Planning Application No: 6/2020/3420/MAJ - Biopark, Broadwater Road, Welwyn Garden City, AL7 3AX (Sport England Ref: PA/21/E/WH/57352)

Summary: An **objection** is made to the proposals for community sports facility provision to meet the needs of the proposed development in its current form due to the lack of proposed provision. This position would be reviewed if it was proposed that appropriate financial contributions would be made towards off-site indoor and outdoor sports facility provision, secured through a section 106 agreement, as set out in this response.

Drawing file: BMD.20.044.DR.P304A Planting Plans - Roof Gardens (Sheet 2 of 2).pdf

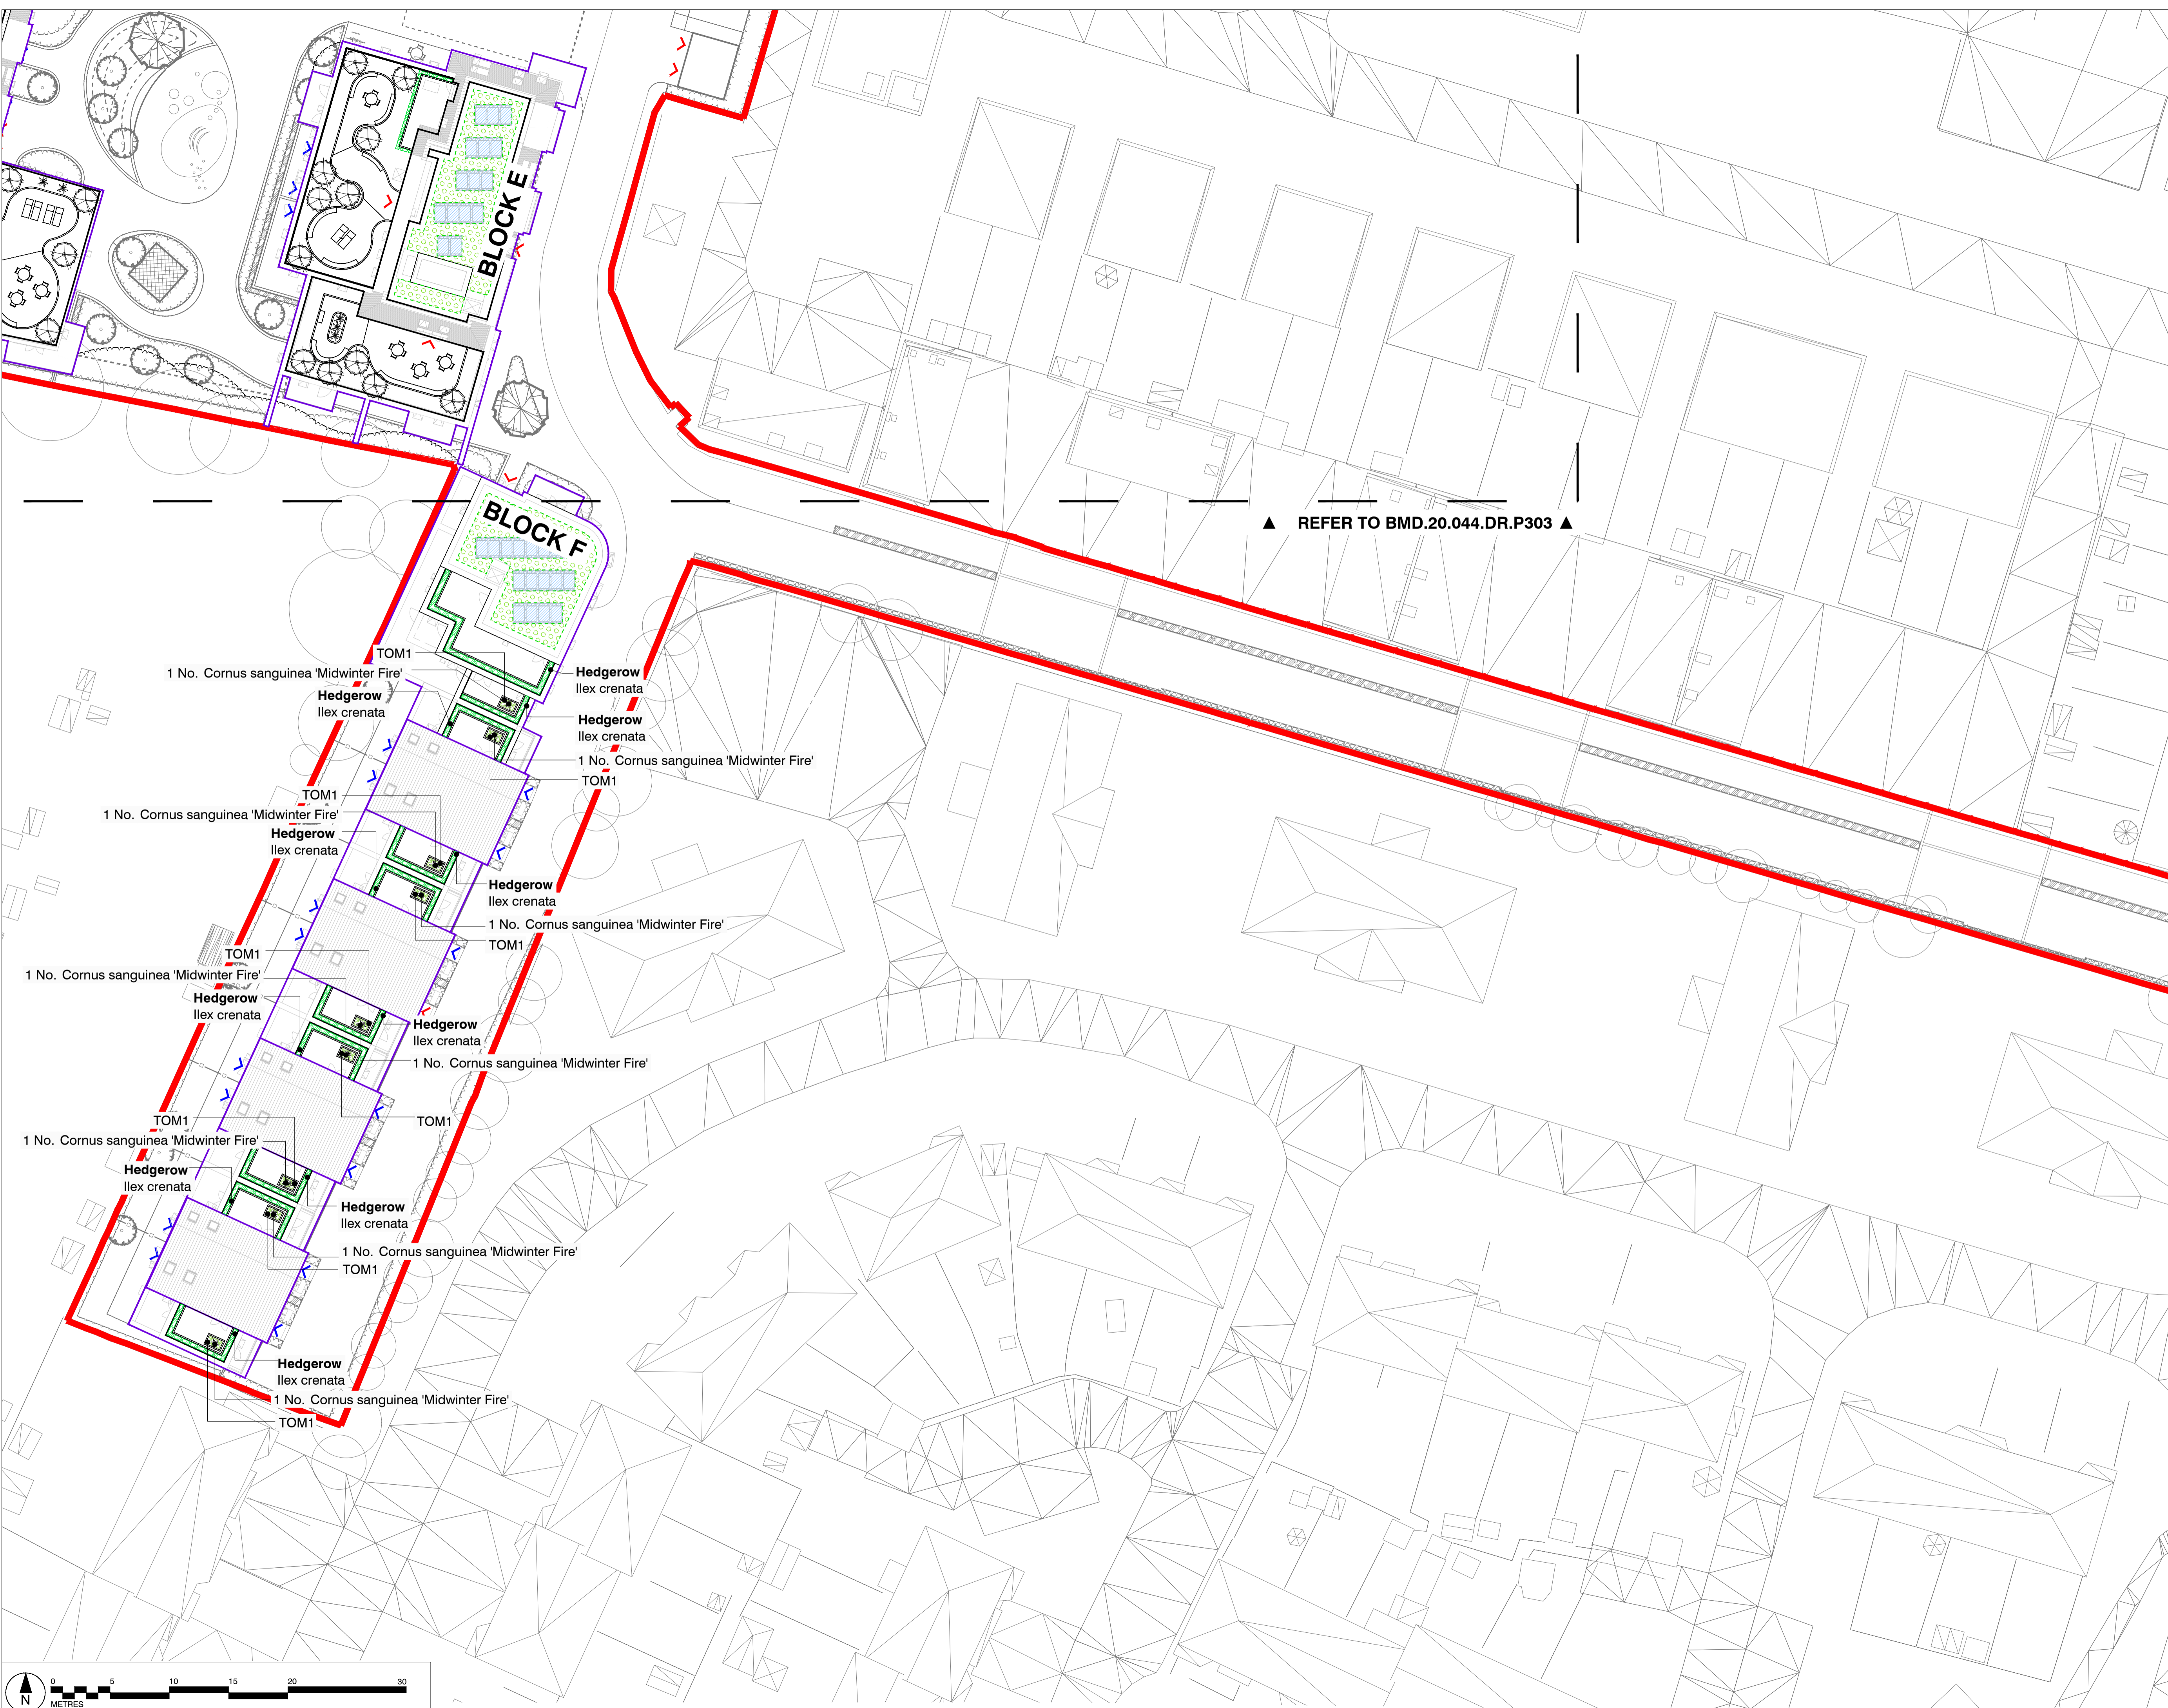
• The rooftop gardens are welcomed in principle and consideration should be given to whether outdoor gym equipment could be provided to offer the opportunity for informal physical activity.
